R/294/21/HH - Single storey rear extension and conversion of roof space to habitable use to include a rear dormer - 8 Botany Close Rustington BN16 2BJ.

Drawing
PROPOSED PLANNING OBJECTION

PROPOSED ROOF PLAN
DRAWING

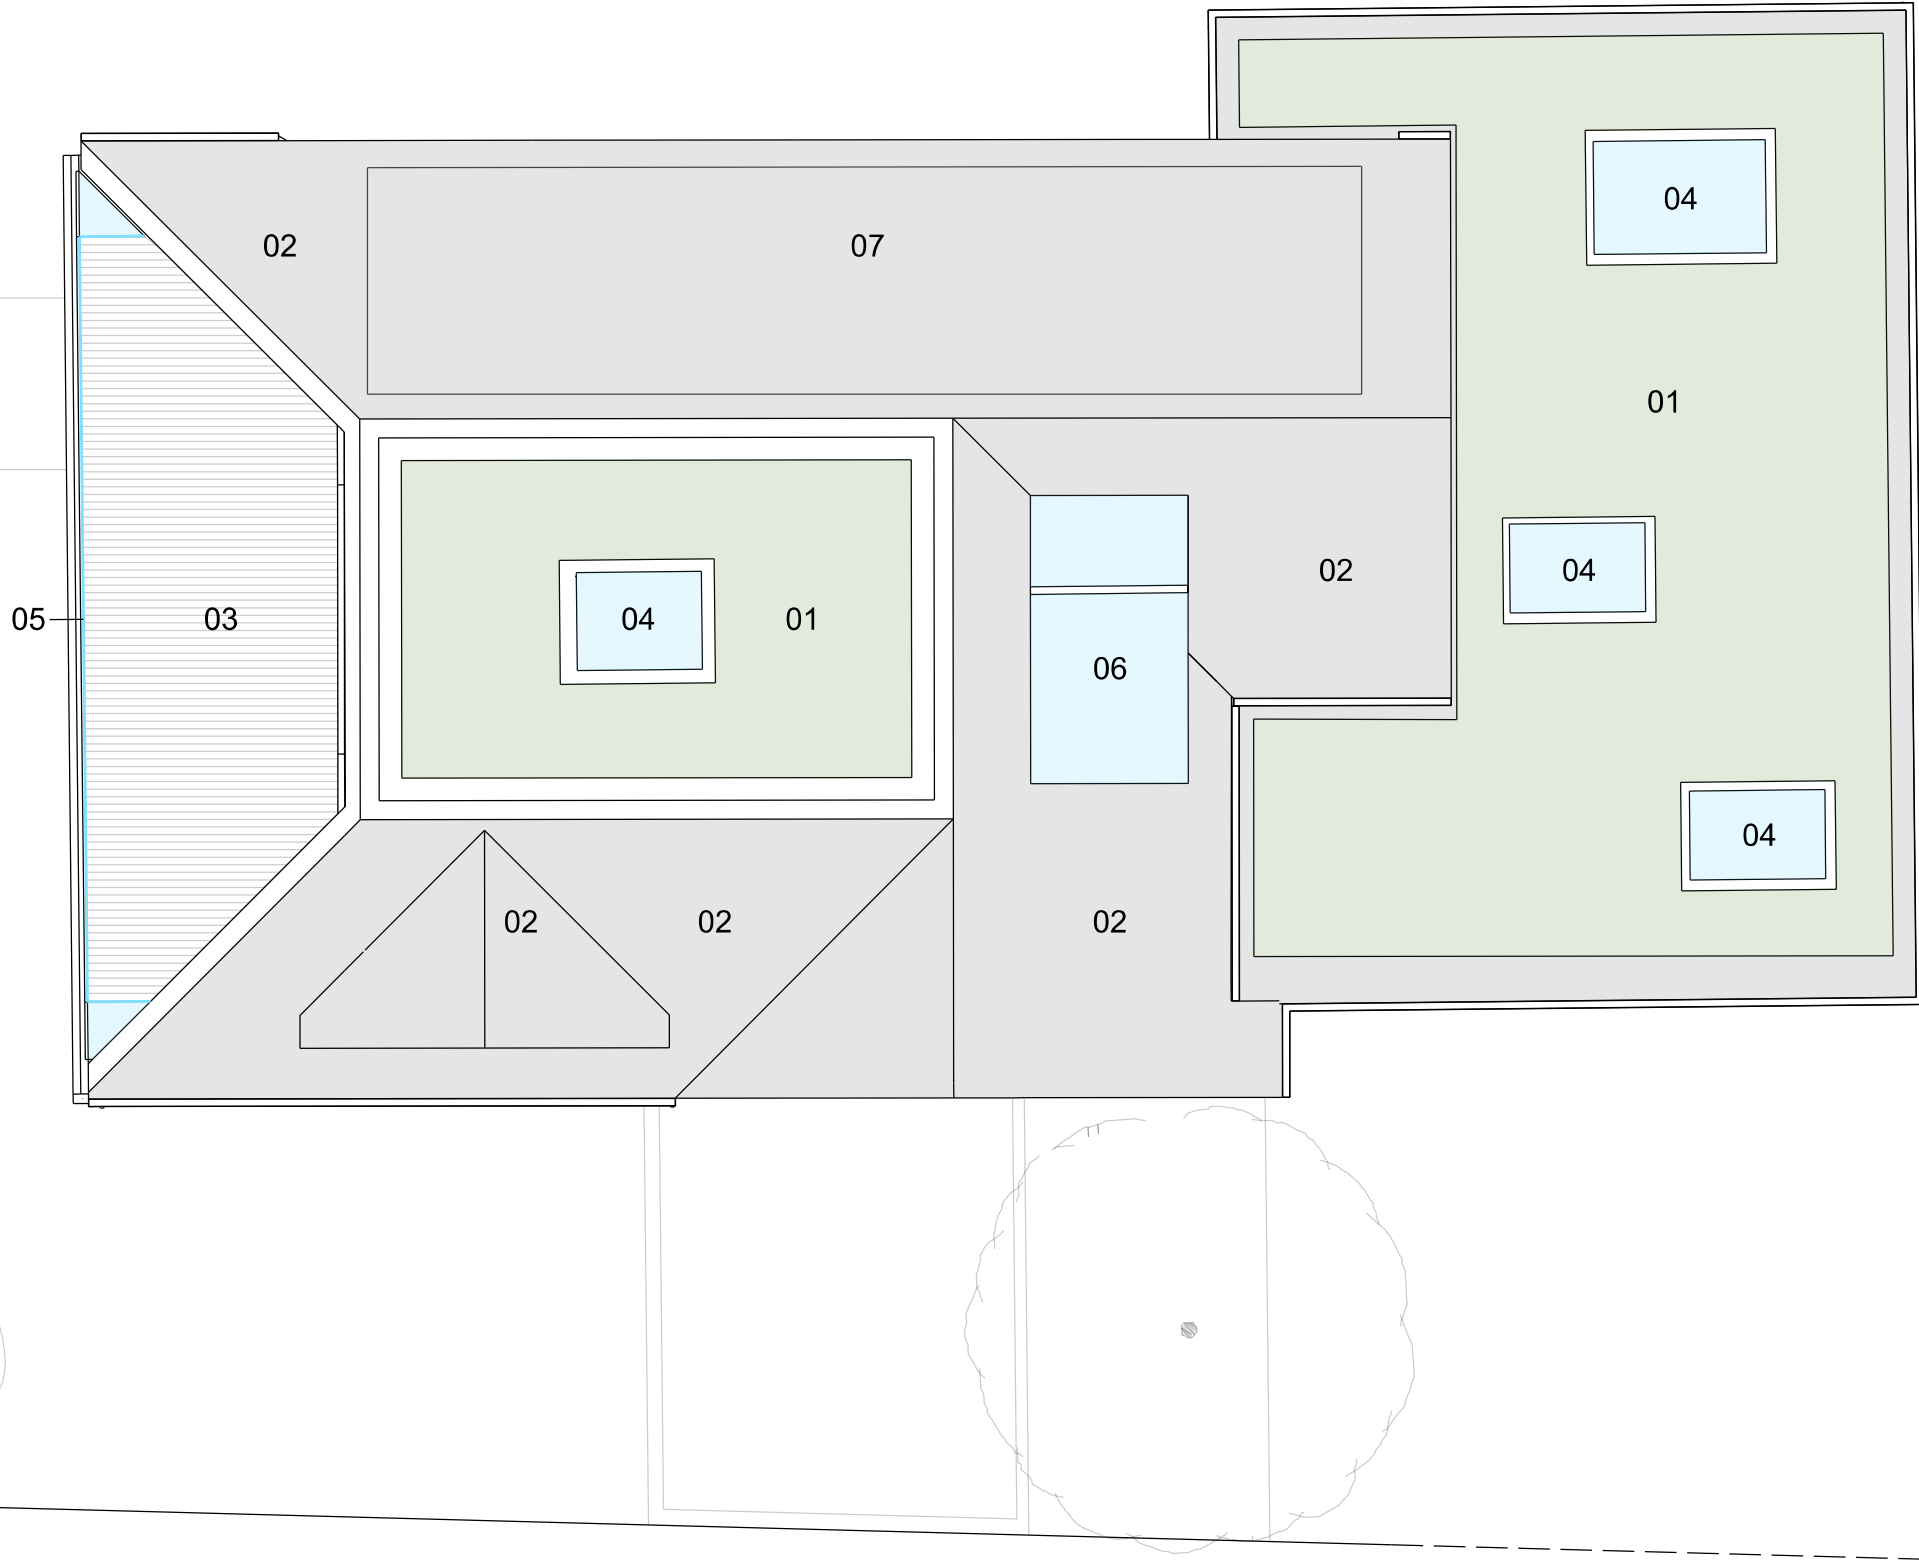
LARGE DORMER WINDOW WILL CAUSE LOSS OF LIGHT AND OVERSHADOWING OF ADJACENT PROPERTY. THE DORMER WINDOWS WILL ALSO CAUSE LOSS OF PRIVACY TO NOT ONLY THE ADJACENT PROPERTIES GARDEN BUT WILL ALSO HAVE DIRECT LINE OF SIGHT INTO THE VELUX WINDOW SERVING THE BEDROOM OF THE PROPERTY AT 8a.

PROPOSED ELEVATIONS
DRAWING

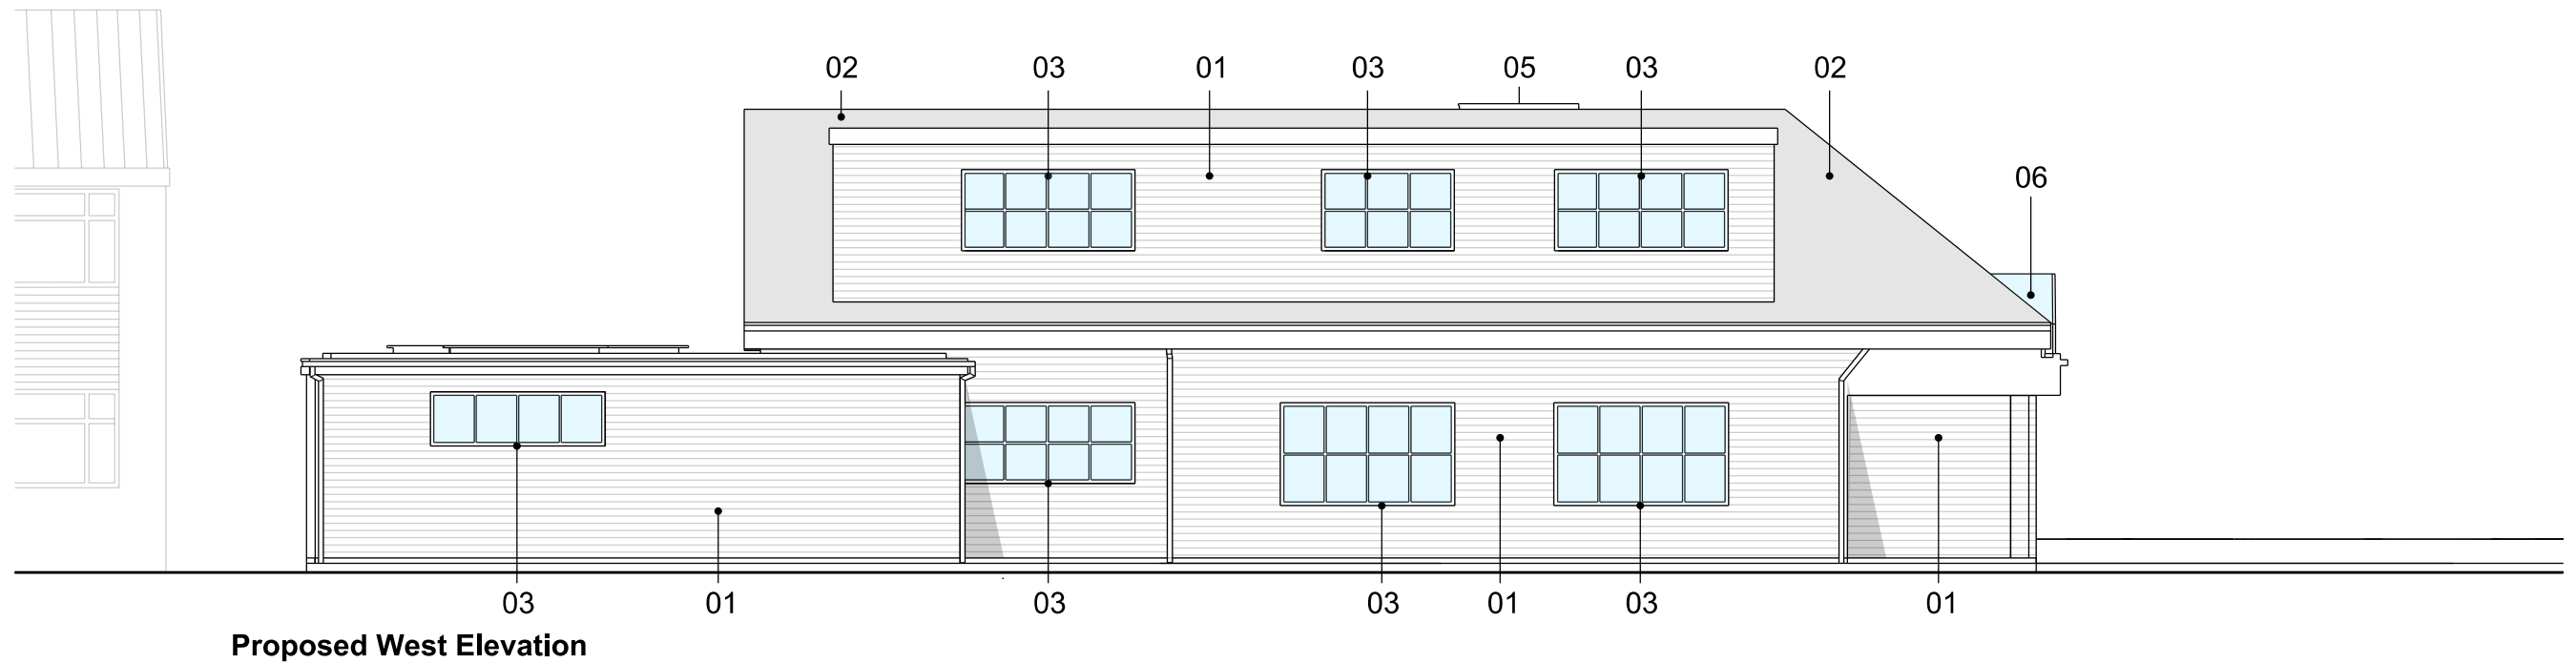
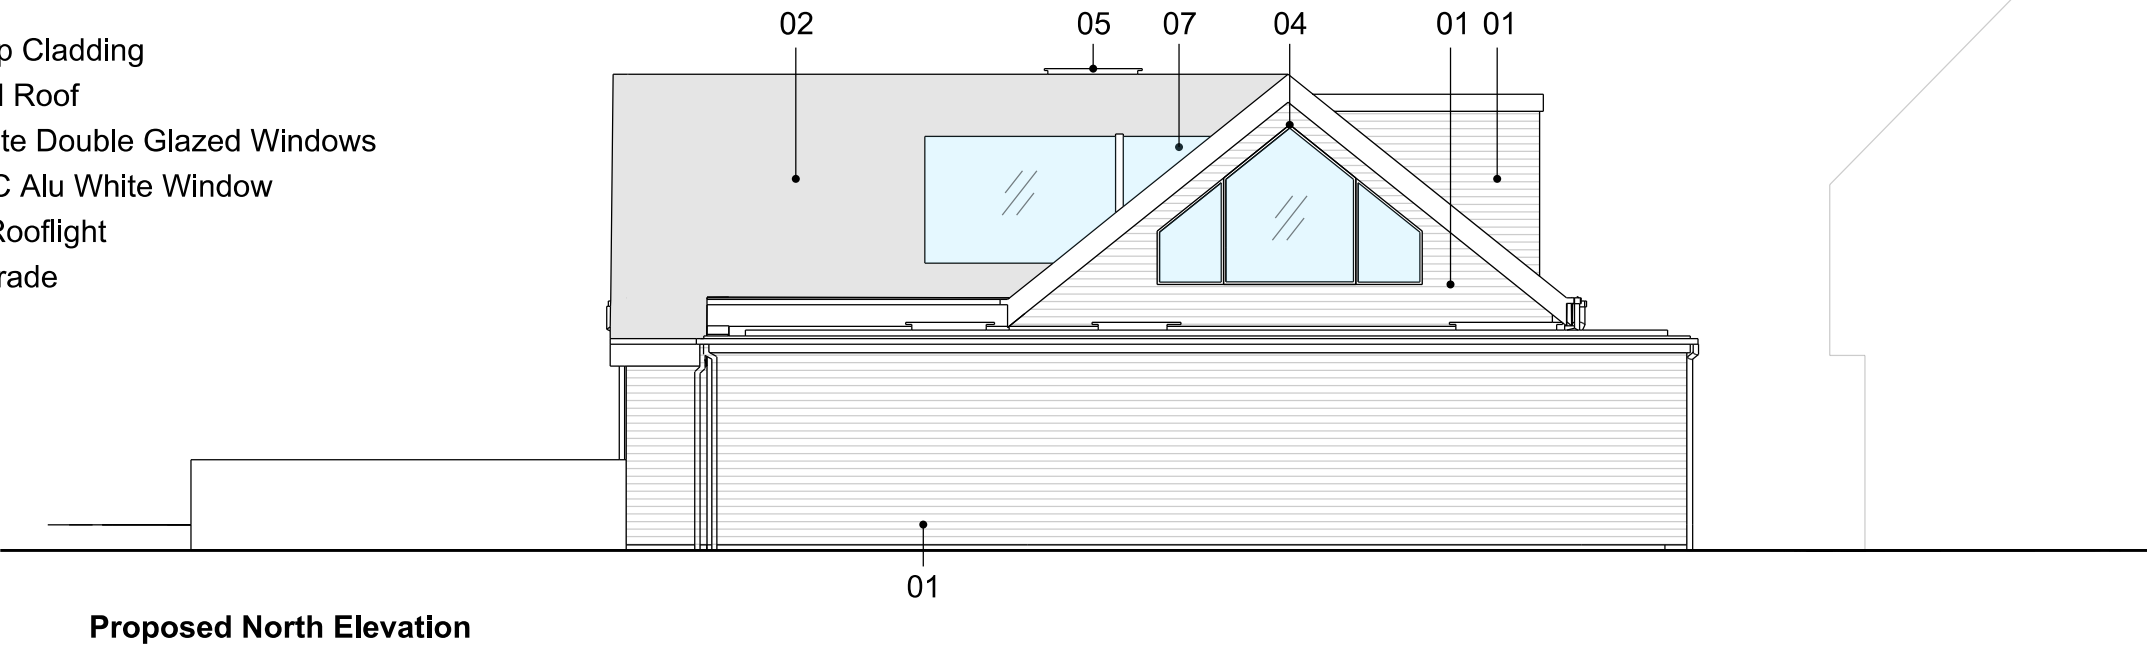
NUMBER 8 - PROPOSED WEST ELEVATION INCLUDES 18.92 m2 OF GLAZING.

BUILDING REGULATIONS PART B4 STATES THAT IF ANY PART OF THE DWELLING WALL ADJACENT TO THE BOUNDARY IS WITHIN 1000mm OF THE BOUNDARY A MAXIMUM UNPROTECTED ARE OF 1.0m2 IS ALLOWED.

THE GROUND FLOOR BEDROOM TO THE REAR OF THE PROPERTY (LABELLED ITEM 12 ON THE APPLICATION DRAWING FLOOR2A) IS WITHIN 800mm OF THE BOUNDARY THEREFORE THIS ELEVATION CANNOT HAVE MORE THAN 1.0m2 UNPROTECTED OPENING. SEE ITEM 11.6 OF BUILDING REGULATIONS PART B.

WHILST IT IS ACCEPTED THAT THE WALL TAPERES AWAY FROM THE BOUNDARY, THE ANGLE IS NOT GREATER THAN 60% AND THEREFORE THE PROPOSAL DOES NOT COMPLY WITH DIAGRAMS 11.2 & 11.7 OF PART B4.
